Appeal Decision

Appeal Ref: APP/R5510/W/20/3261507

**Verge on Breakspear Road, adjacent to junction with Fine Bush Lane,
Ruislip HA4 7SS**

- The appeal is made under section 78 of the Town and Country Planning Act 1990 against a refusal to grant approval required under a development order.
- The appeal is made by MBNL (EE Ltd and H3G (UK) Ltd) against the decision of the Council of the London Borough of Hillingdon.
- The application Ref 65930/APP/2020/1831, dated 12 June 2020, was refused by notice dated 31 July 2020.
- The development proposed is the installation of a 20m monopole, 12 No antenna apertures, equipment cabinets and development ancillary thereto.

Title: **266 MAX CONFIGURATION ELEVATION -
SHEET 2**

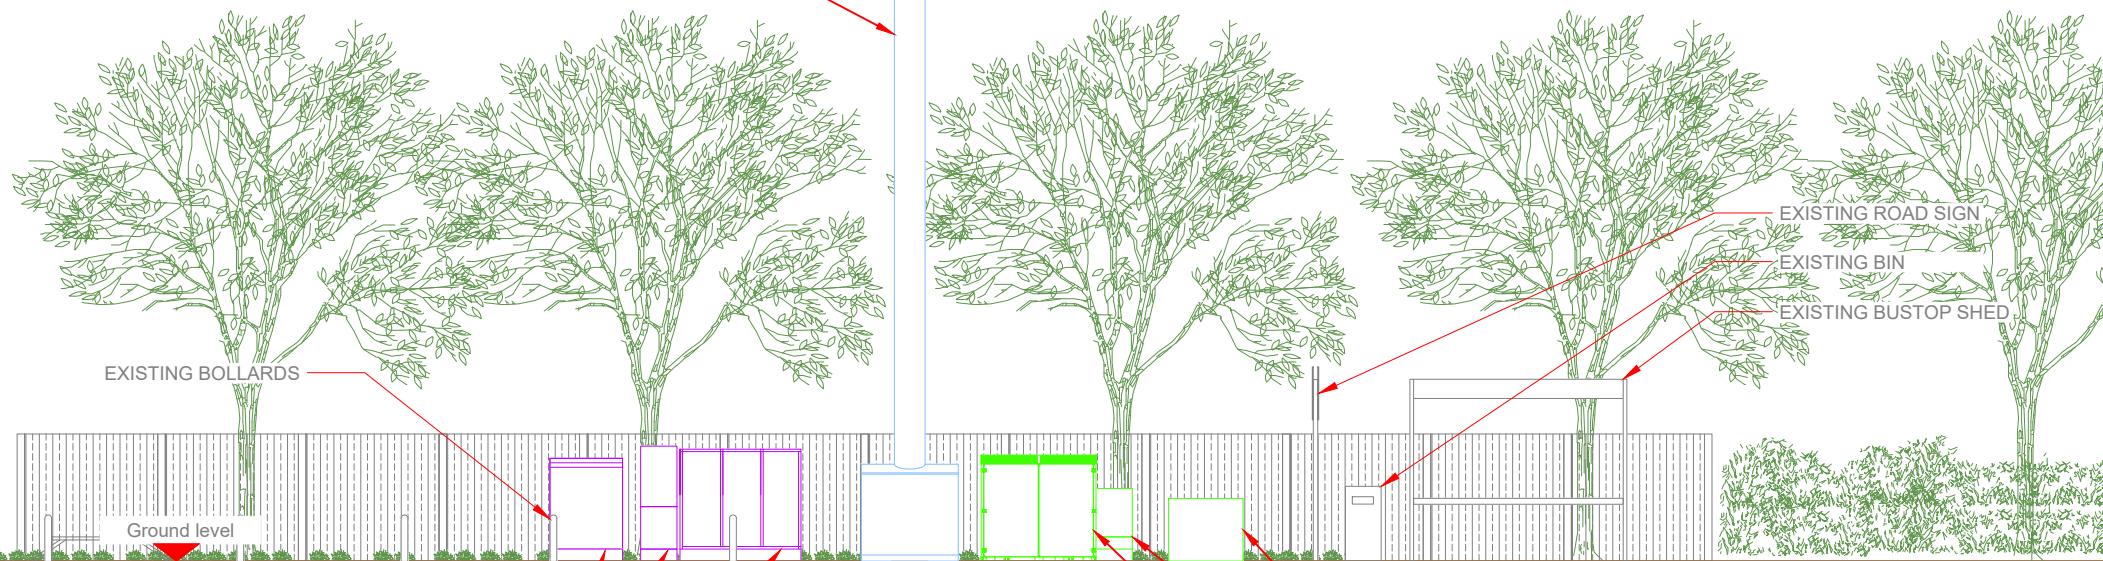
5. The proposal would have a wide base and main body and its upper sections would accommodate the antenna apertures. The proposal would represent a tall feature within the area. It would be taller than the adjacent buildings by some significant margin, and taller than the street-lights and the existing

telecommunications monopole. Combined with its position, where clear views would be available, and taking account of its width, I consider that the monopole would have a significant and negative visual effect when seen within the area. Its position adjacent to the open land within the Green Belt would accentuate this effect.

6. There is planting along parts of the adjacent garden boundaries which, along with the fences, would screen the lower sections of the proposal. However, it is clear that the upper parts of the proposal would be visible from a number of the residential properties to the east. I consider that where these views are from the nearest properties, including their rear gardens, that the proposal would be particularly dominating and unacceptable.
